**SUPPLEMENTARY INFORMATION**

Site Name	Land at Tittenhurst Park	Site Address	Land southwest of Tittenhurst Park, London Road, Ascot, SL5 0PP
NGR	E: 494966 N: 168167		
Site Ref Number	95980	Site Type	Macro

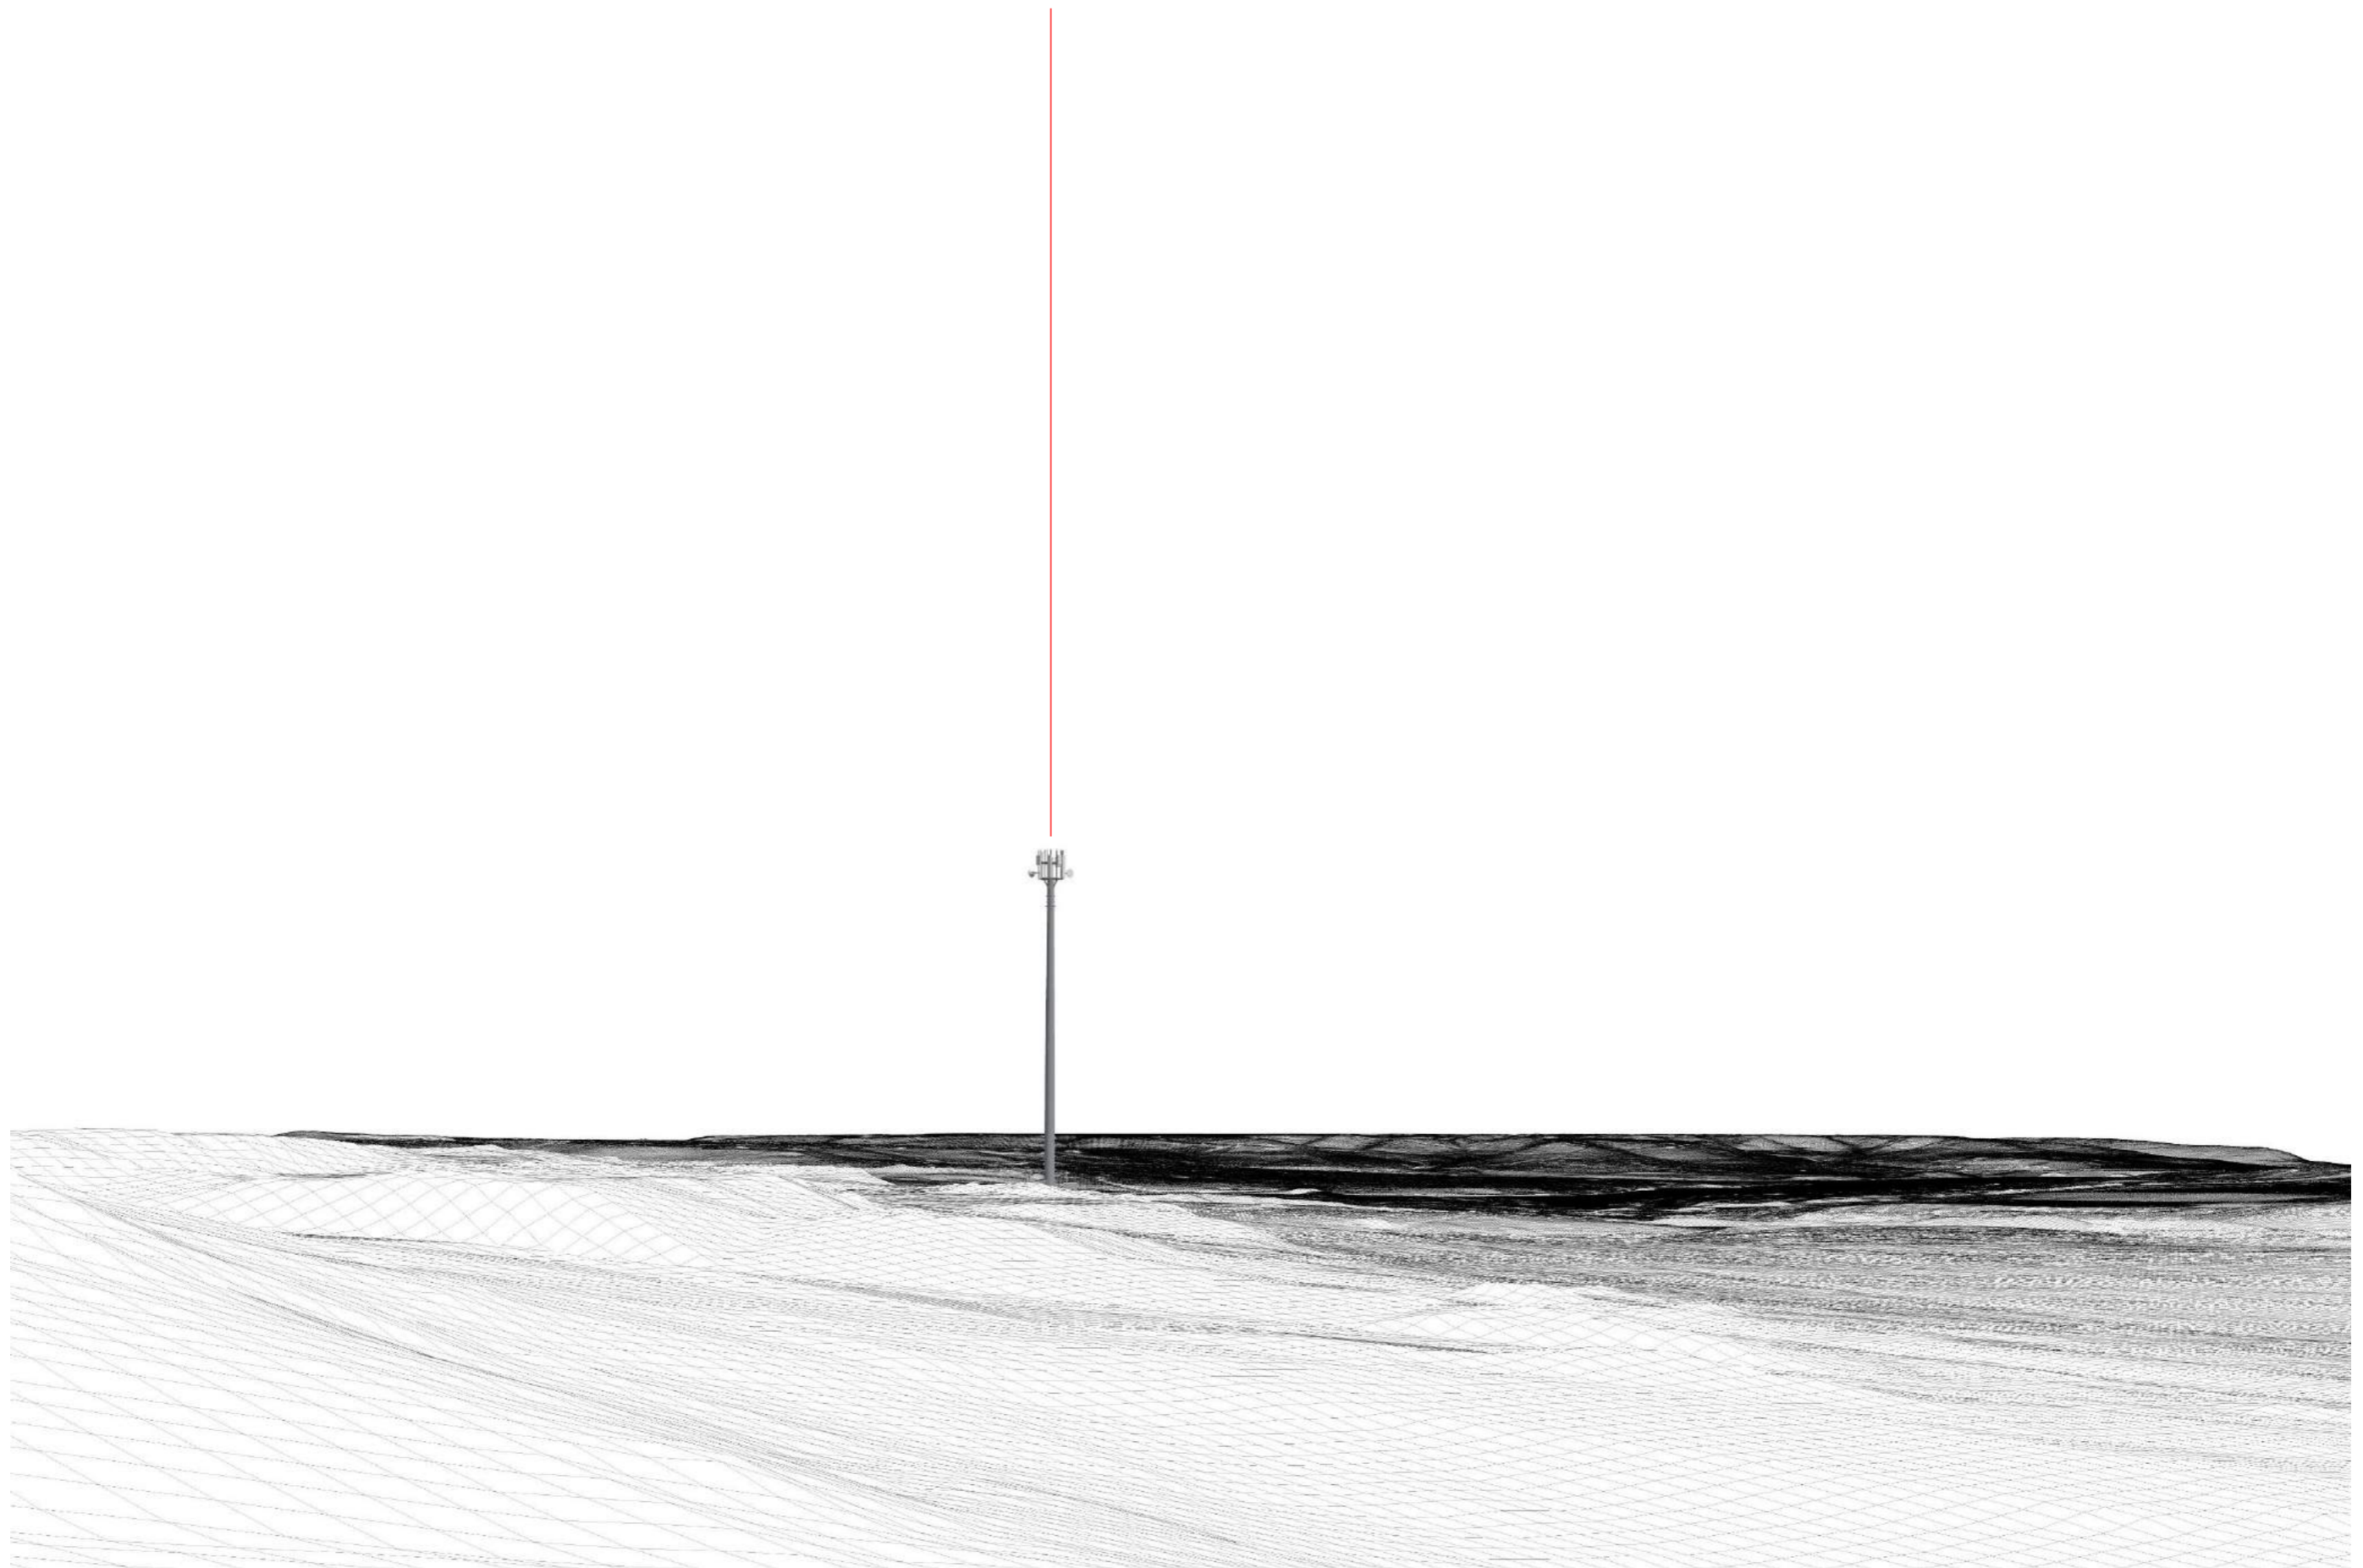
*“The impact on local character, landscape and heritage assets will be a key consideration. I note the intention to submit an LVIA but in the absence of that information we are unable to give any detailed advice on the likely acceptability of the scheme. There are some comments regarding the precedent set by the existing mast and the screening of the trees but given the proposed height of the mast I would not consider that the existing mast justifies this nor that surrounding trees would offer substantial screening. Based on information seen to date I would be concerned at the visual impact of the mast in this location.”*

Applicant Response – Given the site is located within a Greenbelt, a Photo Montage Report has been included from surrounding viewpoints. The existing mast sets the precedent that telecoms infrastructure is generally acceptable at this location in comparison to other sensitive locations in this area. Regarding the mature trees in this area, as can be seen from the Panoramic Survey Report enclosed in this application, the trees measure between 10m-30m which means there is sufficient screening for long range views when taking into account other natural vertical elements within the landscape. As demonstrated within the enclosed Photo Montage Report, visuals from public vantage points are mitigated as far as possible and the proposal is screened by trees from these viewpoints. Therefore, the visual impact from long range views is expected to be minimal on this area even given the height of 30m proposed.
